Nationally Significant Infrastructure Project: EN01027

Mallard Pass Solar Farm

**Post Hearing Submission prepared by Lincolnshire County Council
Issue Specific Hearings & Action Point Responses – July 2023**

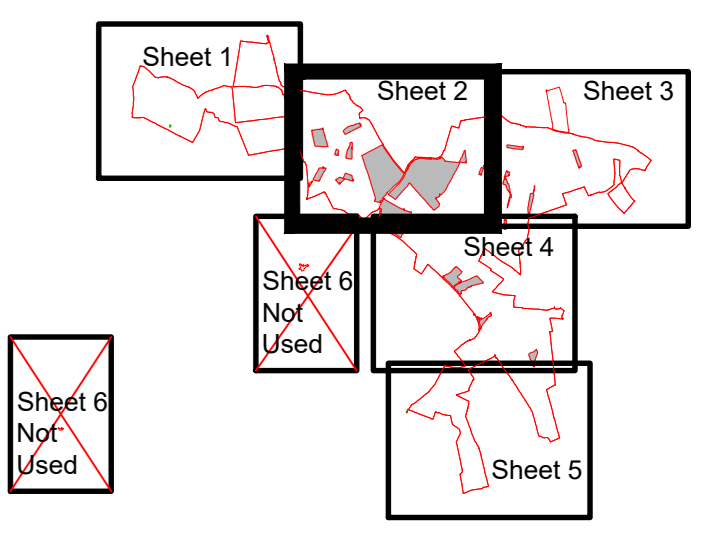
The 15m set back is a good distance to prevent mitigation planting from enclosing routes too oppressively, however, as mentioned previously this would depend a lot on the type of species used and the overall quality of the design. At this stage, the detail of planting is too vague in terms of species mixes and accurate location, etc. More detail is required to enable an accurate judgement of impact to be given. Framed views across the landscape should also be encouraged rather than continuous hedges of the same height and in straight lines.
